Comments from the Bicester Delivery Team, Cherwell District Council

19/01746/OUT – Bicester 10

## PROPOSED SURFACING PLAN

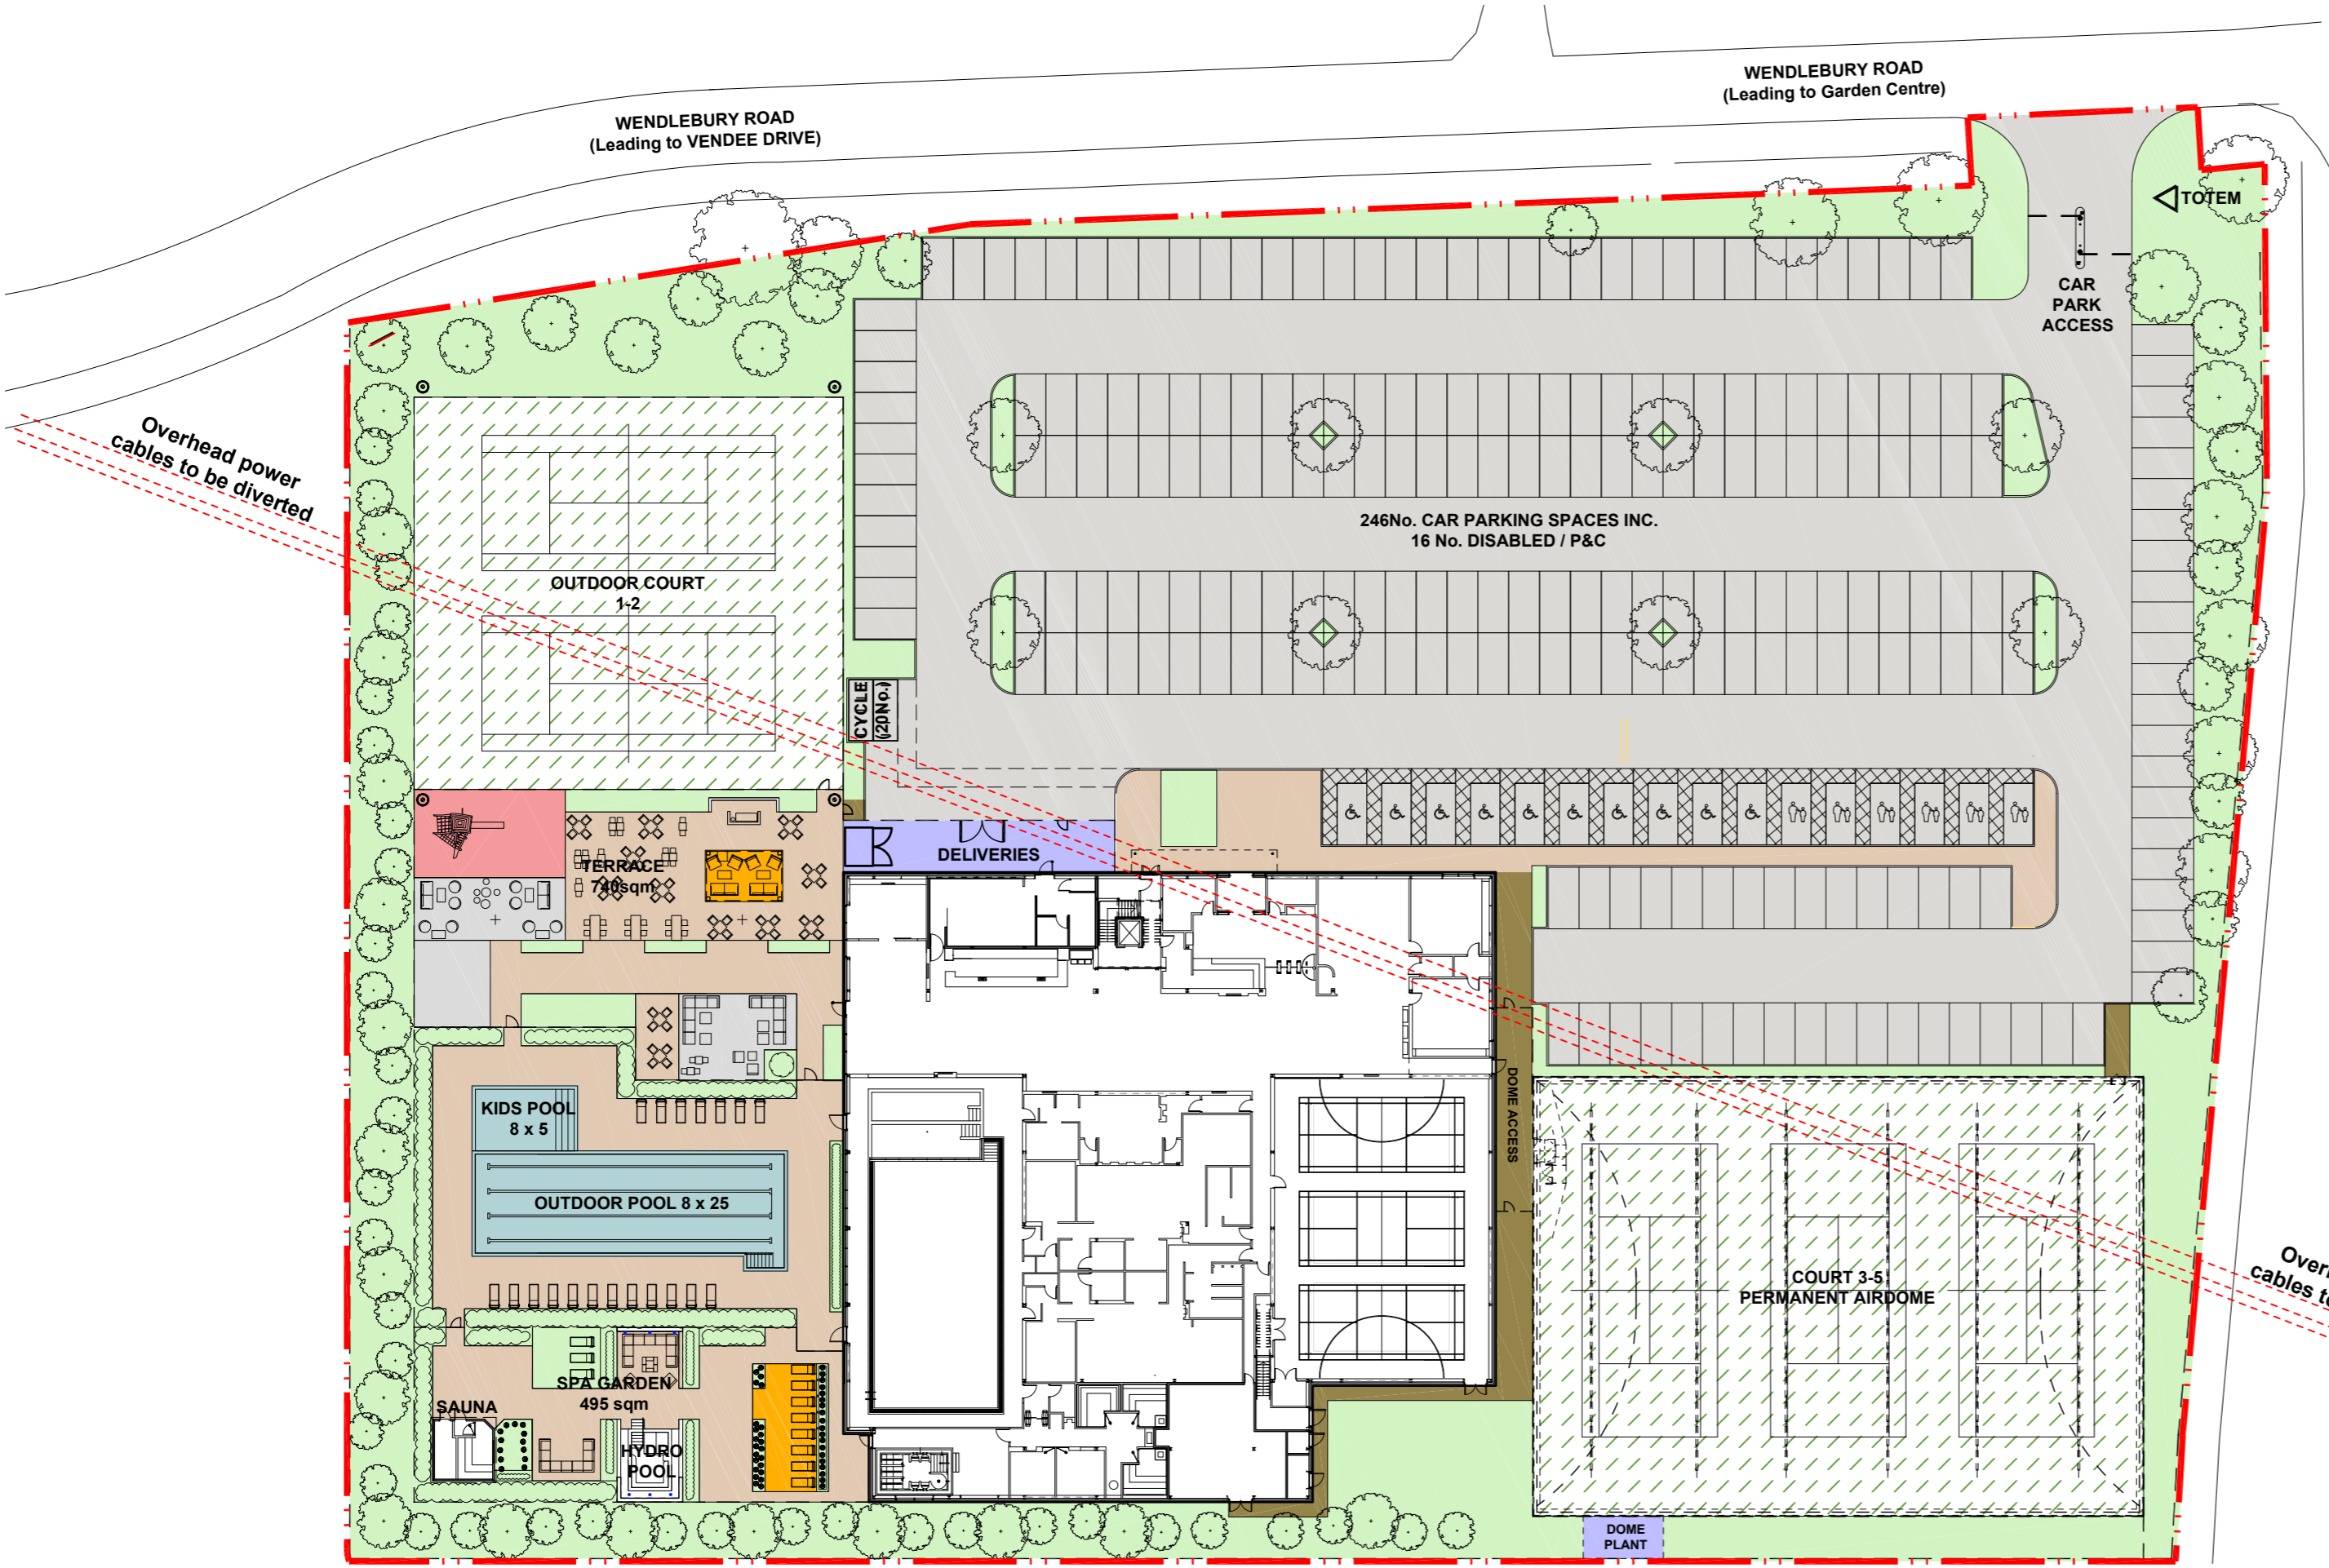
The Transport Assessment doesn't state whether cycle parking is to be covered or where they are to be located. There needs to be a firm commitment to provide covered provision close to the main entrances. The site layout plan only shows the location of cycle parking within the David Lloyd Racquet Centre. This layout requires cyclists to use the vehicular access. **A separate access point from the cycleway should be provided.** The site layout should seek to emphasise that cycling is a key mode for access. Note that OCC's pre-application advice includes the requirement that "a cycle and pedestrian link should also be provided directly into the proposed John Lloyd centre from Wendlebury Road, to minimise walking and cycling distance for users and staff, thereby encouraging sustainable travel."
